Our Ref: AB/105/13/L

Application for Listed Building Consent for redevelopment and conversion of the former Bevin Bevin site to provide 7No. apartments and 6No. houses with associated car parking

Bevin Bevin & Co Ltd River Road Arundel

Drawing
**Location Plan
Site/Roof Plan**

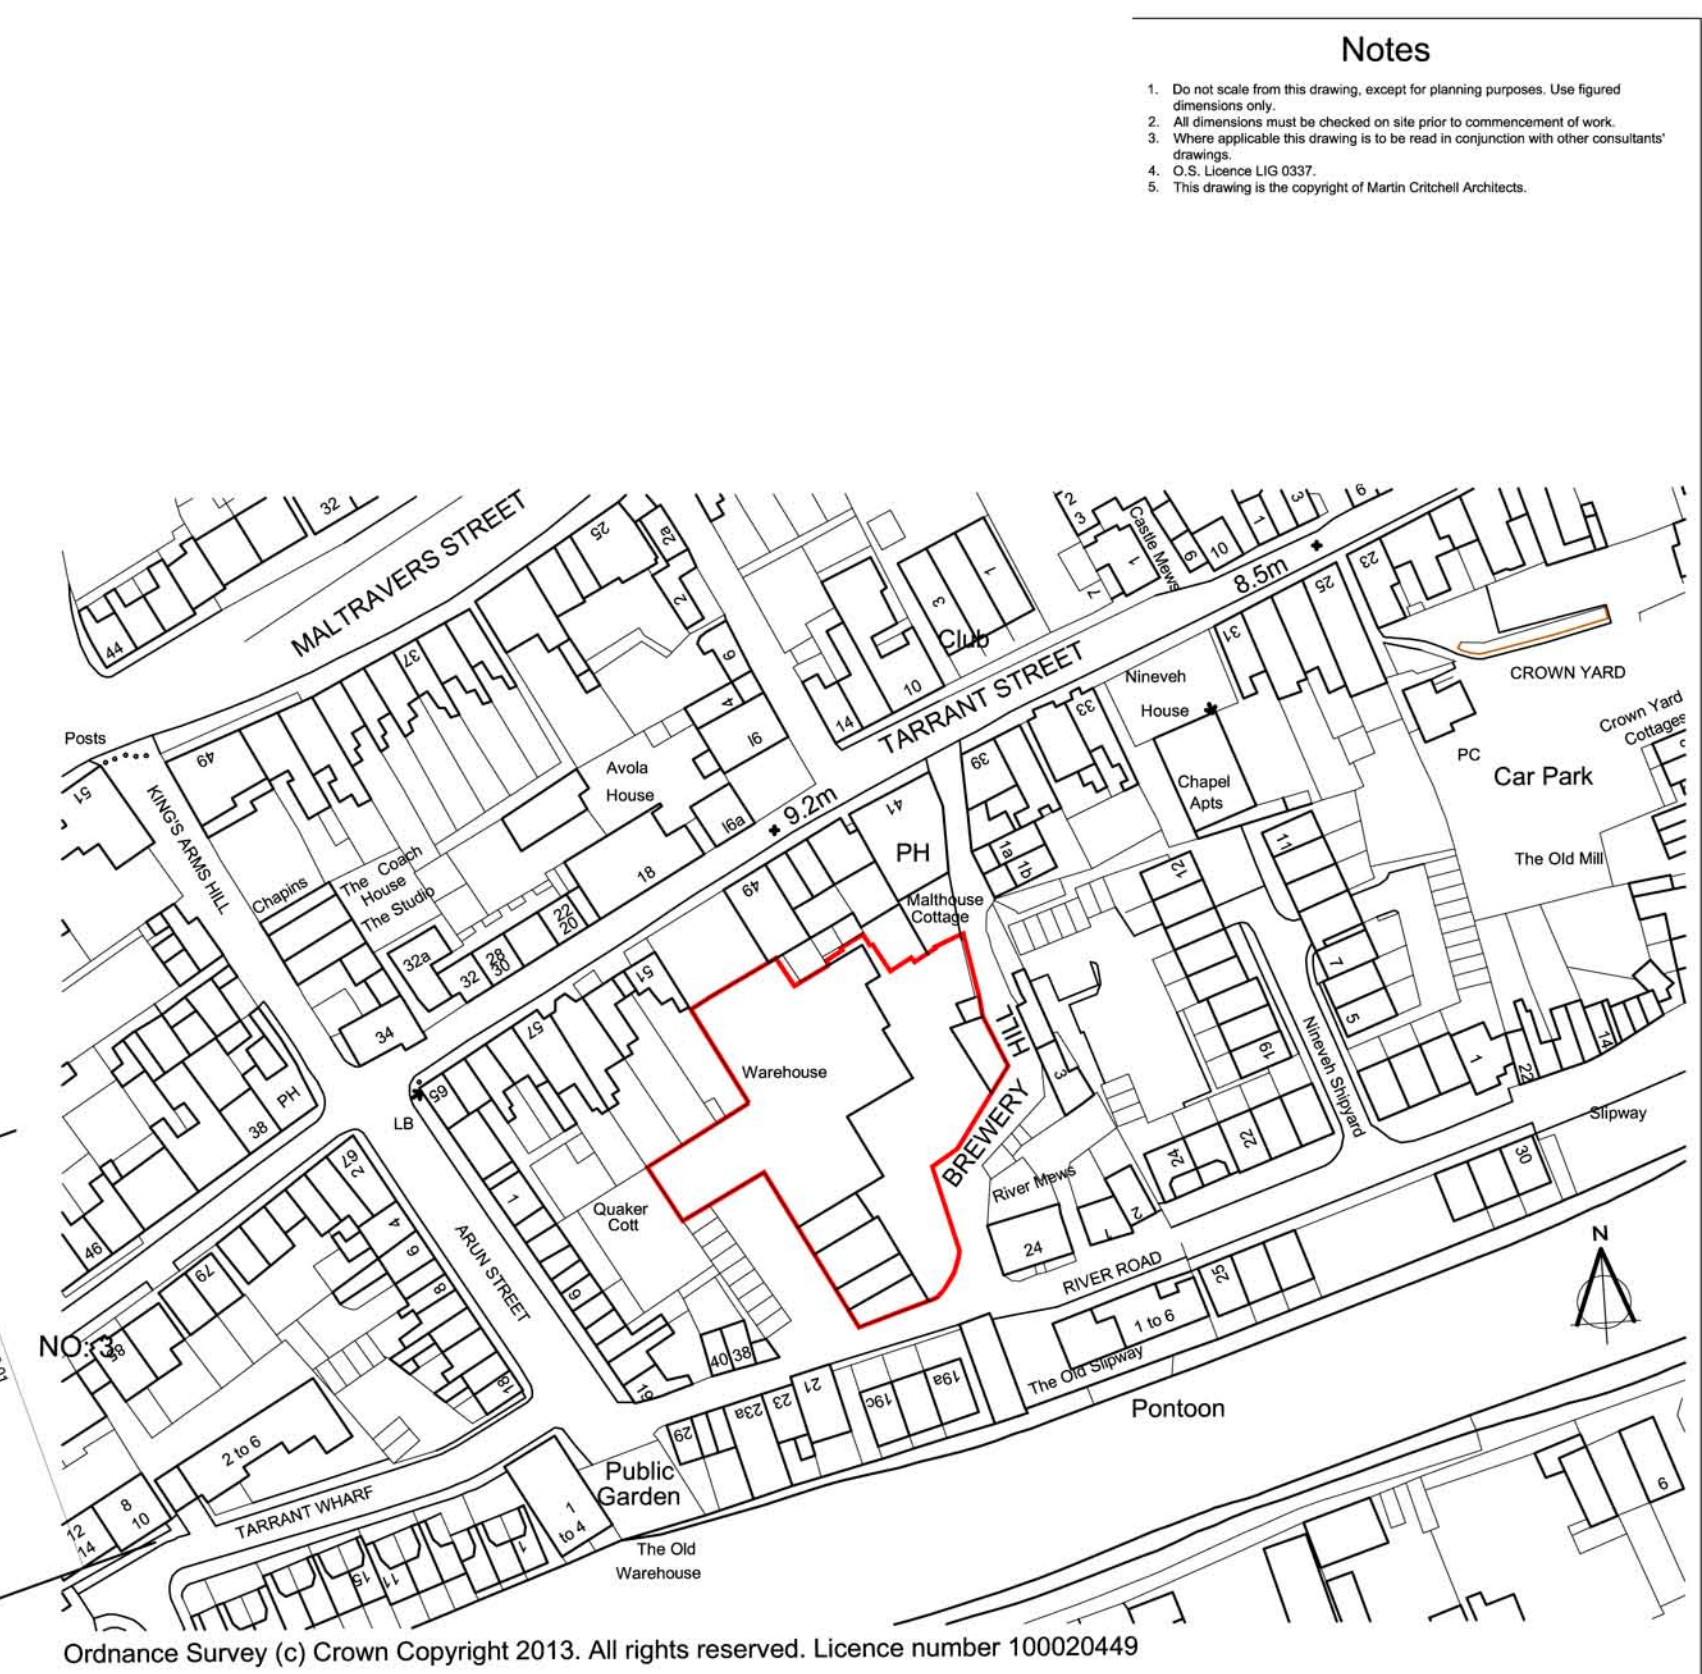
As the owners of Malthouse Cottage, we would like to object to the planning application in respect to the new build apartment 12.

We are concerned about the proximity of this building to the south elevation of our property, as it would detrimentally affect the light levels and sunlight on our balcony, which being the main outside space would have a negative impact.

Also as the proposed new apartment block would be located so close to our property with very little gap, and as the ground level falls away sharply, we are worried about possible detrimental effects to our foundations. Plus it would be almost impossible to carry out any maintenance to the brick wall, soffits, facias or roof of the south elevation of our property.

Therefore for the above reasons we object to the building of Apartment twelve, and suggest that if approved it should at least be located further from our boundary.
